Our Ref: BTC00
Your Ref:
Date: 12th February 2021

**DEADLINE 3 – APPLICATION BY HIGHWAYS ENGLAND FOR A DCO FOR THE A1 IN
NORTHUMBERLAND – MORPETH – ELLINGHAM
COMMENTS ON RESPONSES SUBMITTED FOR DEADLINE 2**

Drawing Number: HE551459-WSP-ELS-A2E-DR-LE-1817
Revision: P04
PW Stage Code: 0

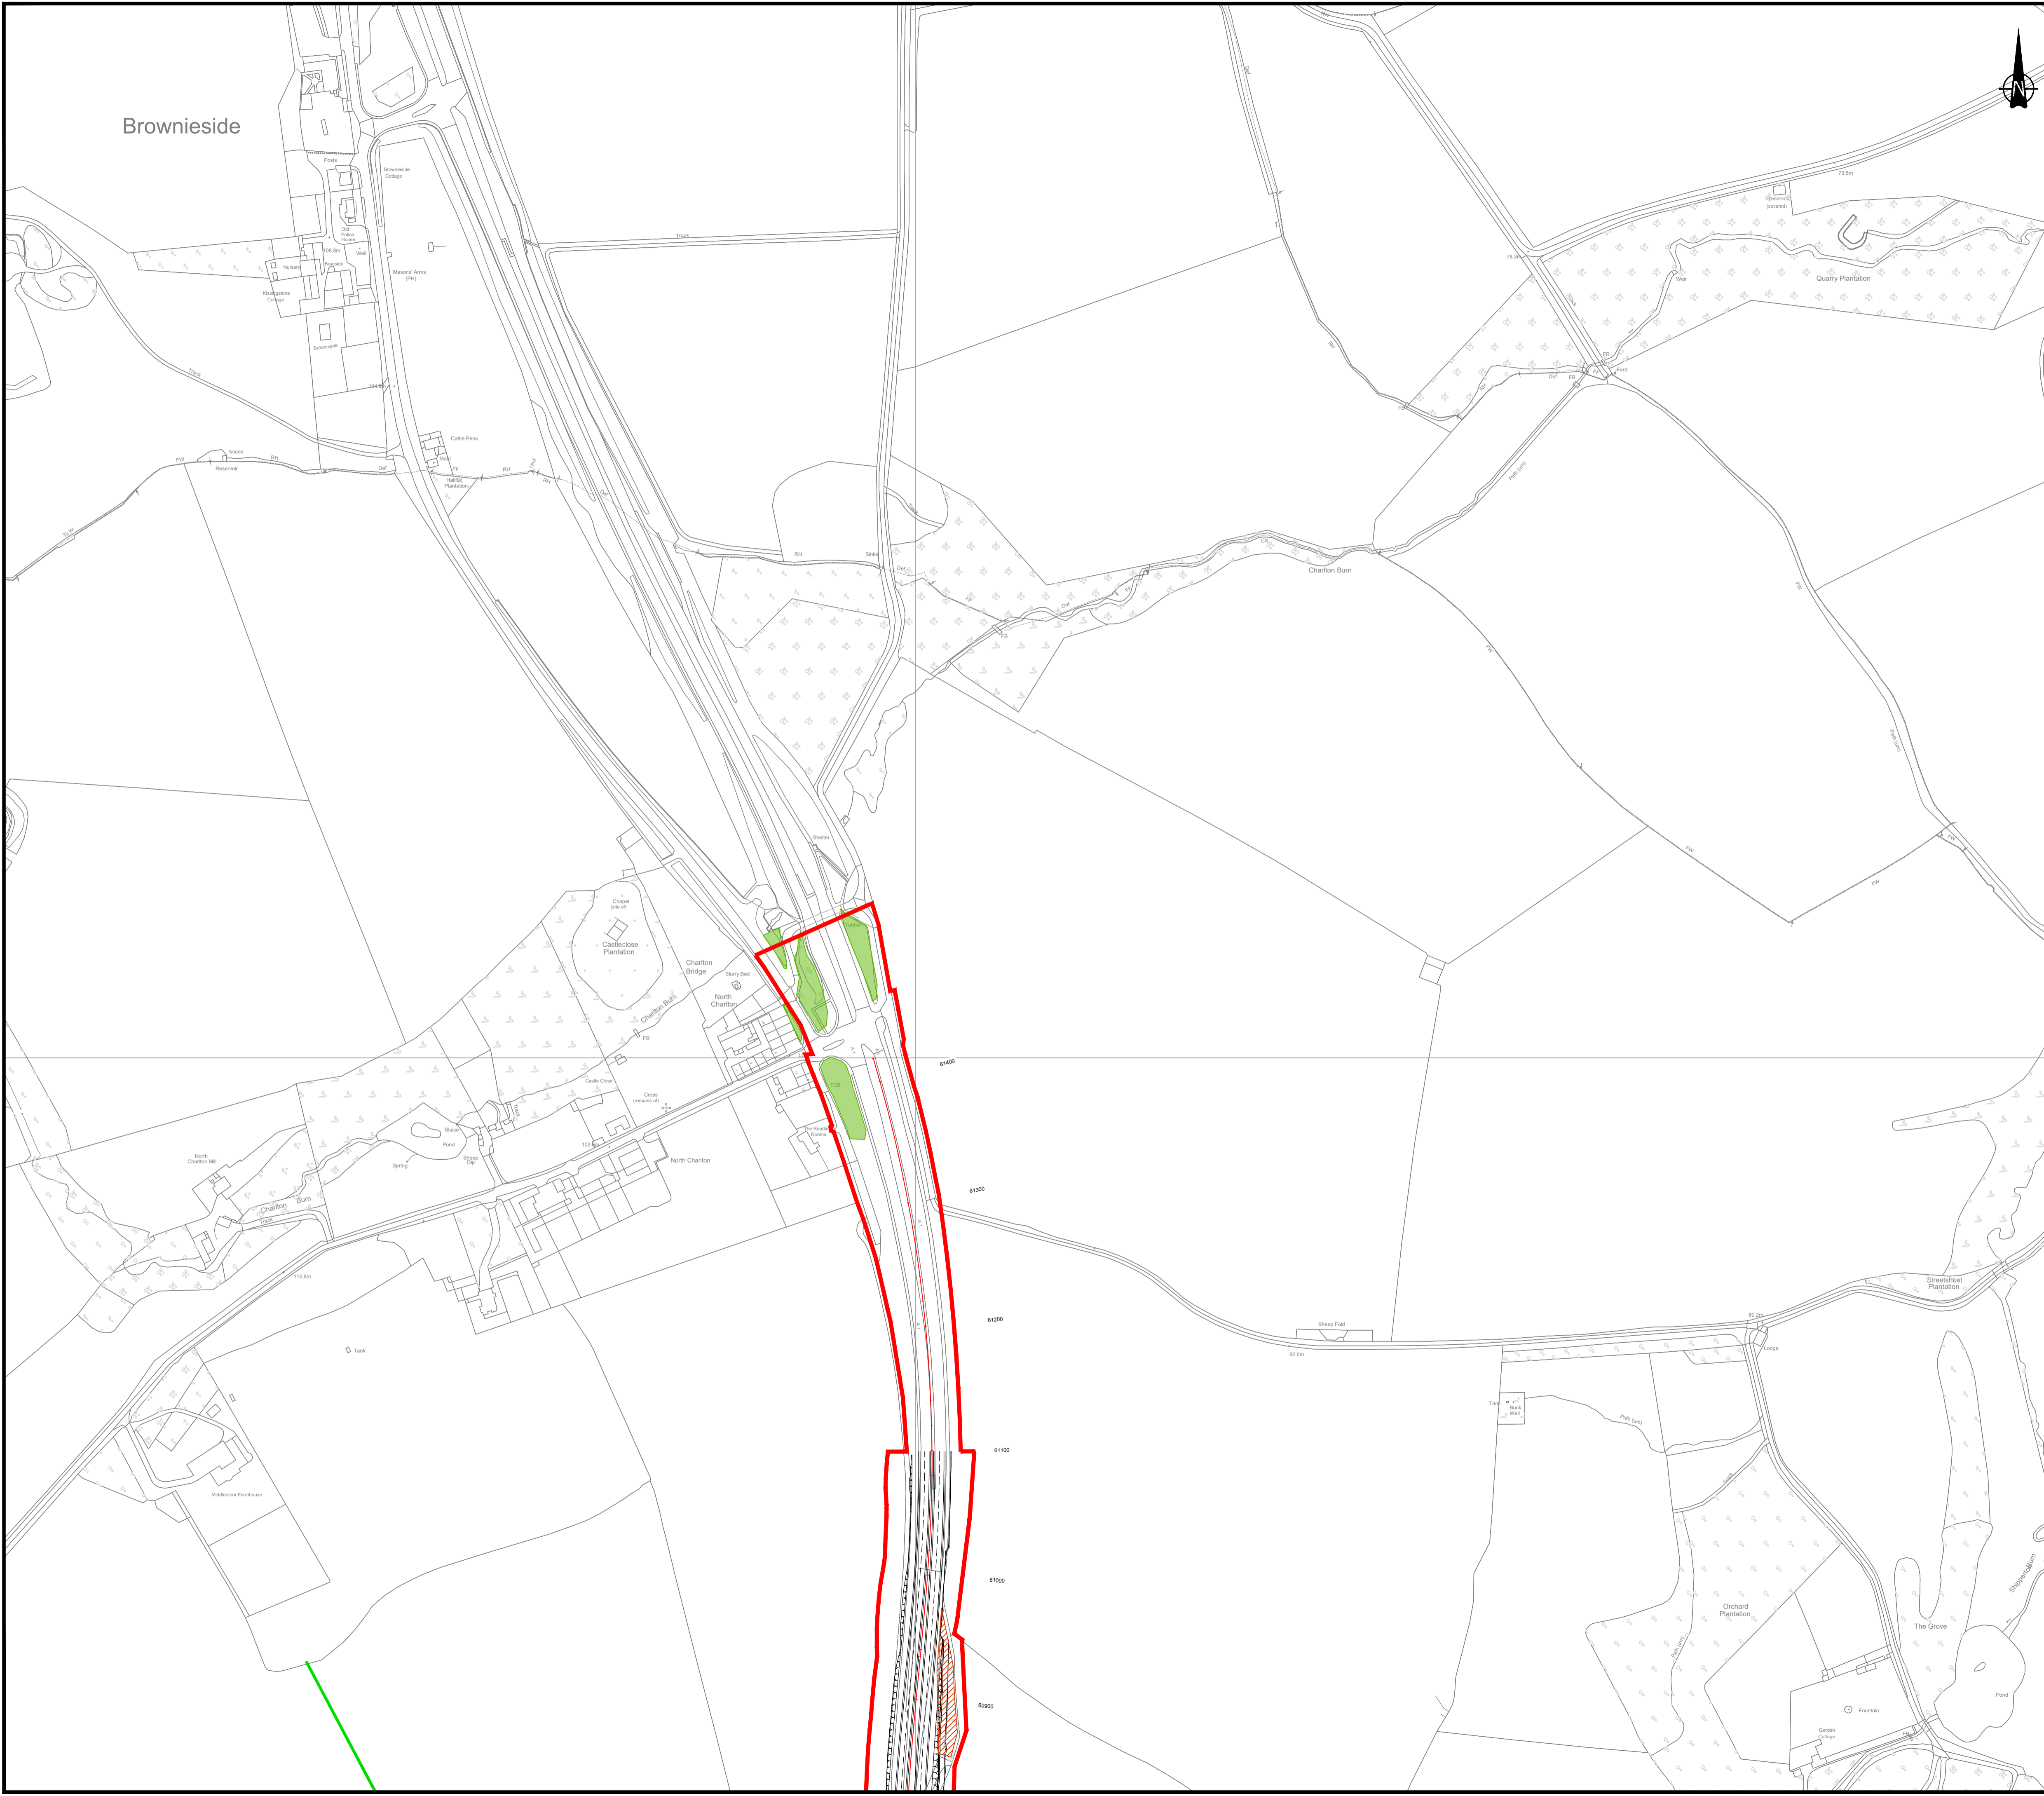
1. Vegetation Clearance –we note submission of Document TR010059 – 001182 6.6 ED Part B Figure 7.11. The document states that vegetation in front of West Linkhall Farm and West Lodge at Charlton Hall is to be removed. We have had verbal confirmation that this is not the case and that whilst some maybe removed, not all of it will be. We are concerned that the DCO is assuming the full removal and we would contest that this is not necessary following conversations with HE and their representatives.
